**CITY OF ALBUQUERQUE
PLANNING DEPARTMENT
February 12, 2014
DRB Comments**

PROJECT # 1009956 APPLICATION # 14-70033

RE: Tracts A & B, Block D, Indian Acres

PLAT OF  
TRACTS A-1 AND B-1, BLOCK D  
INDIAN ACRES

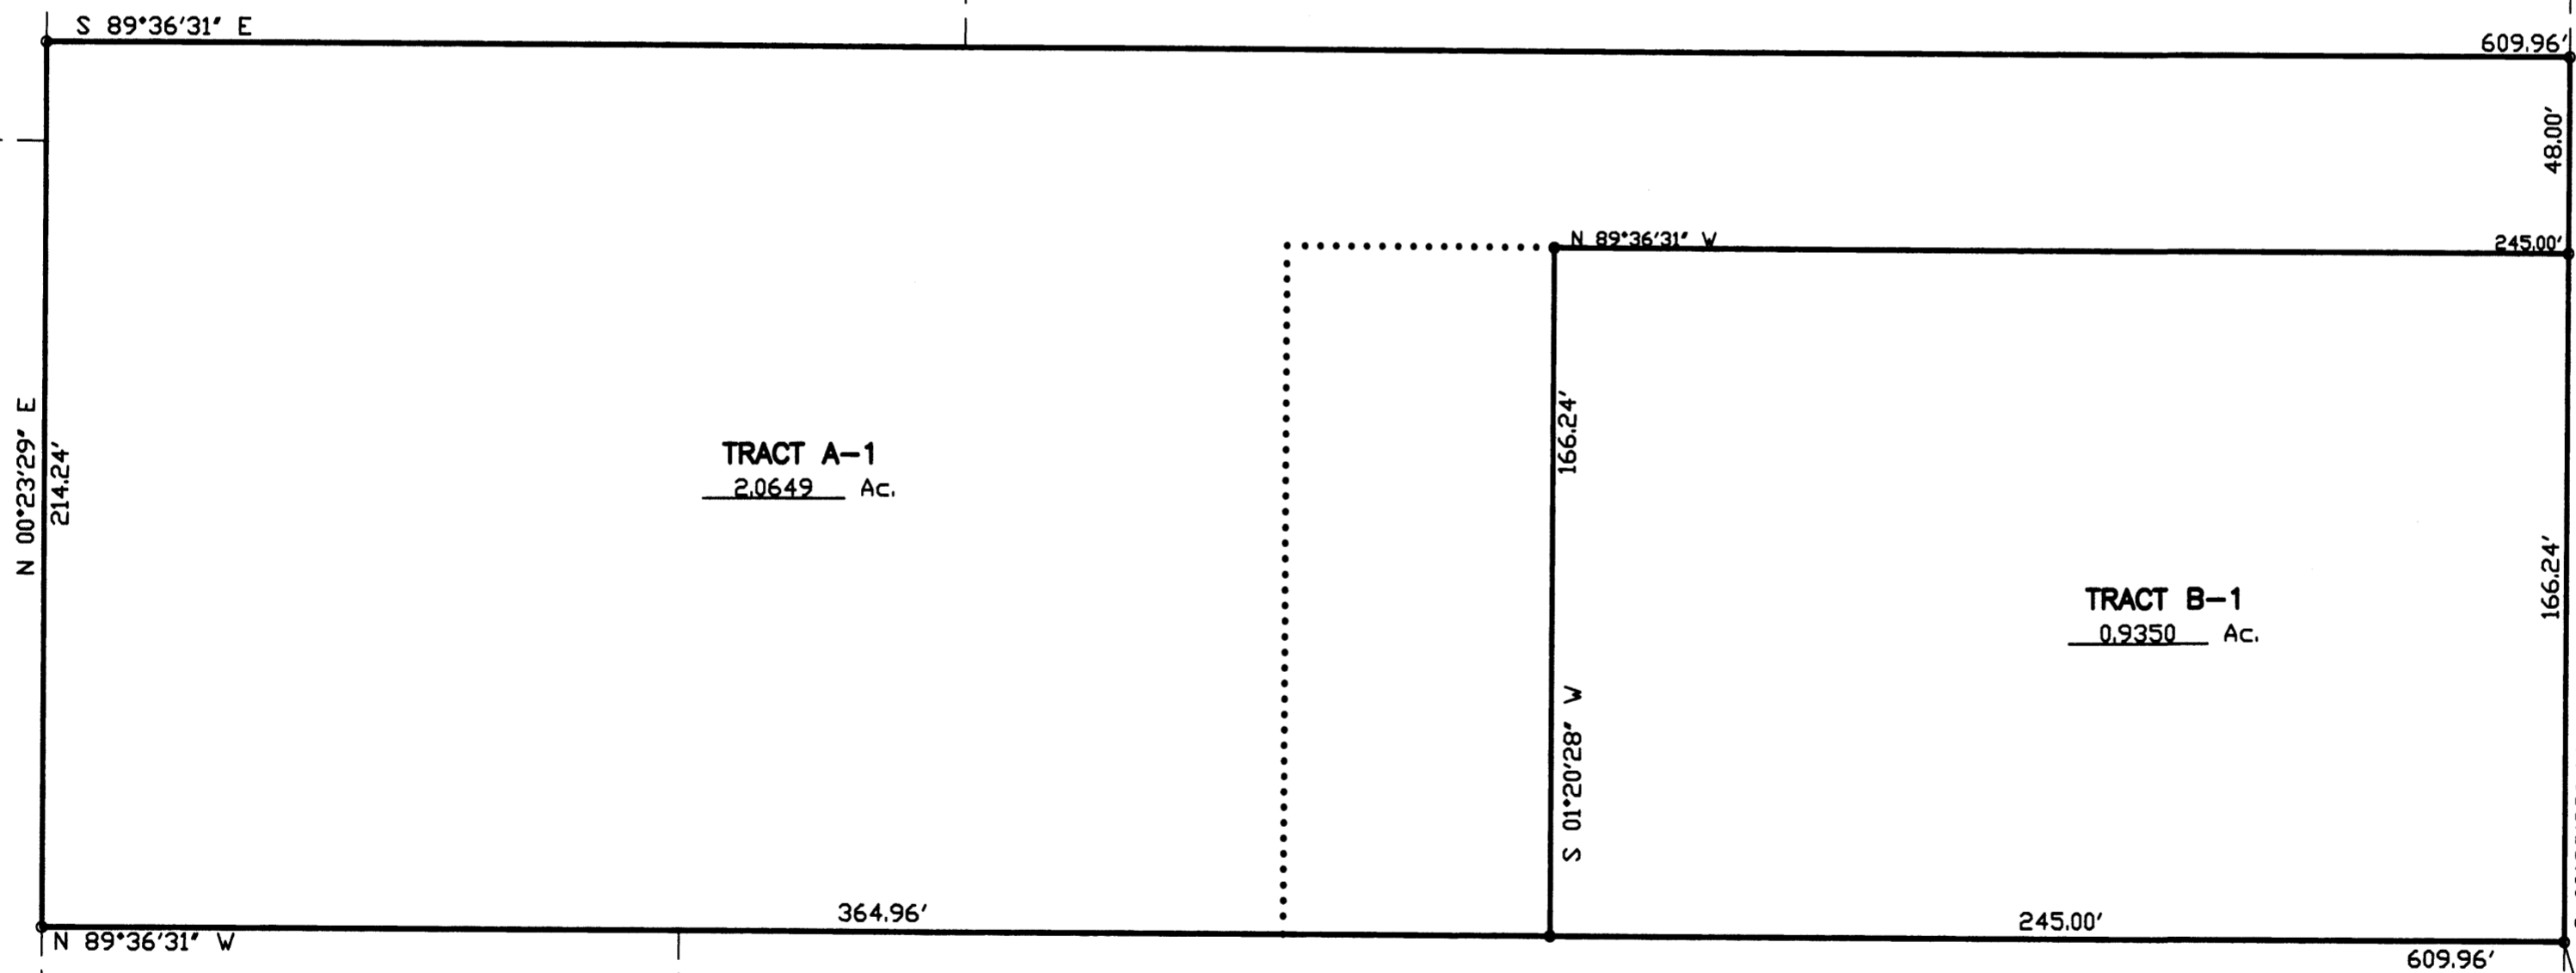
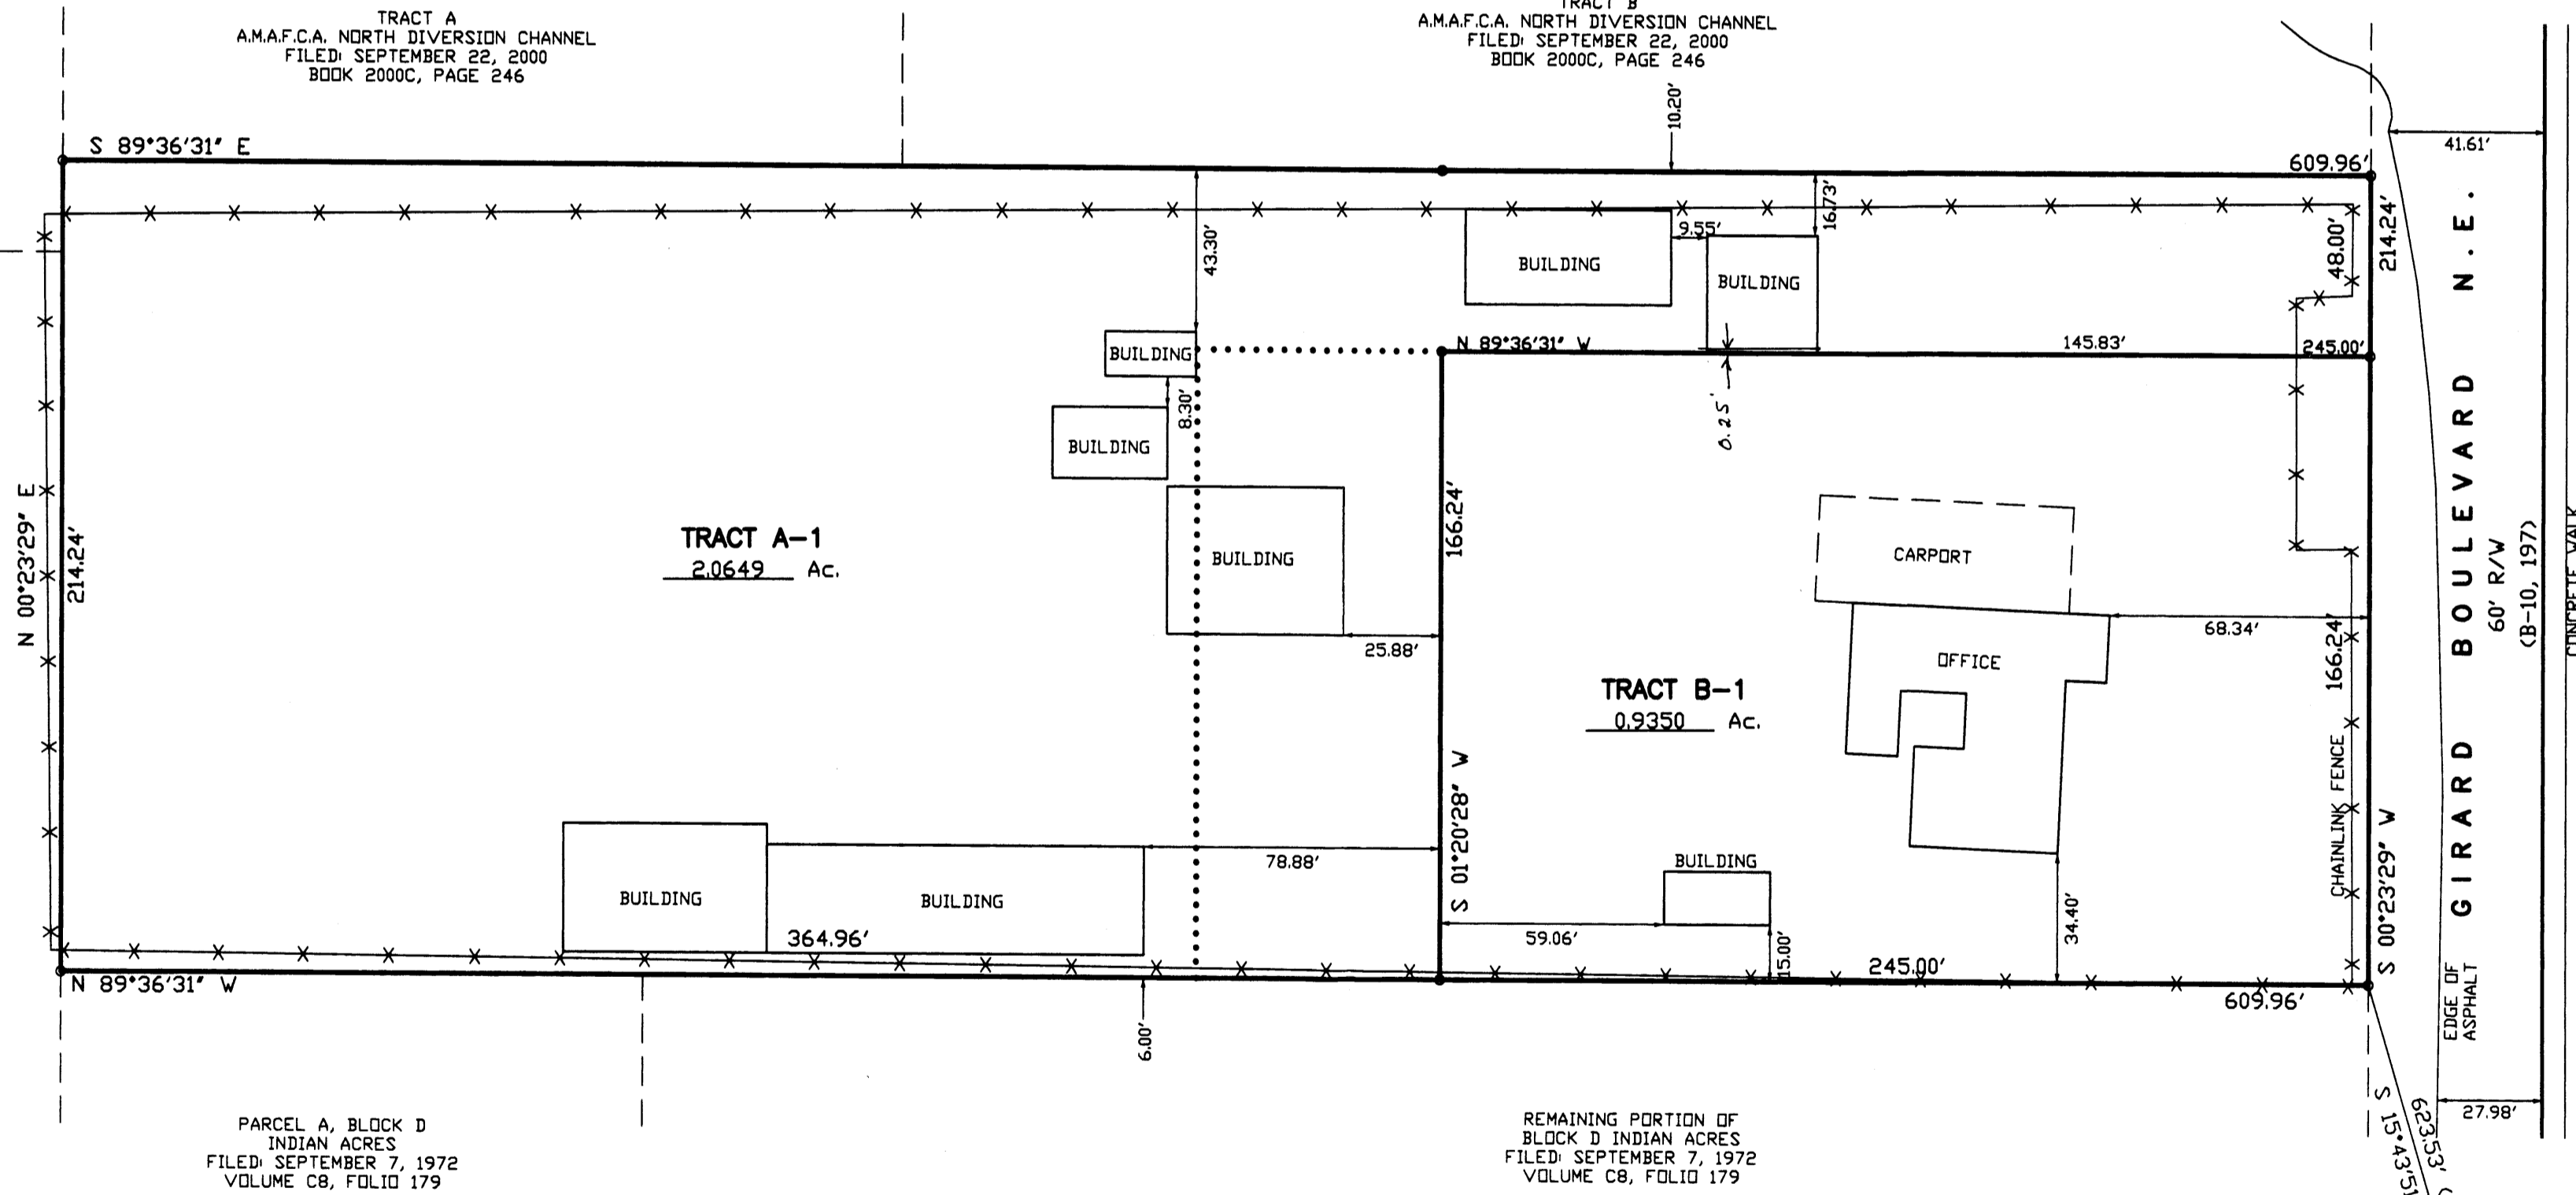
Scale and Graphic scale need to be corrected to conform with plat drawing, or vice versa.

It appears that an Infrastructure List will be required for permanent improvements to Girard Blvd – refer to comments from Transportation Development and Hydrology.

Based on existing development, a shared access easement will be needed.

Based on existing development, a registered architect or engineer will need to verify that the westernmost building on Tract A complies with the building code regarding proximity to the interior lot line.
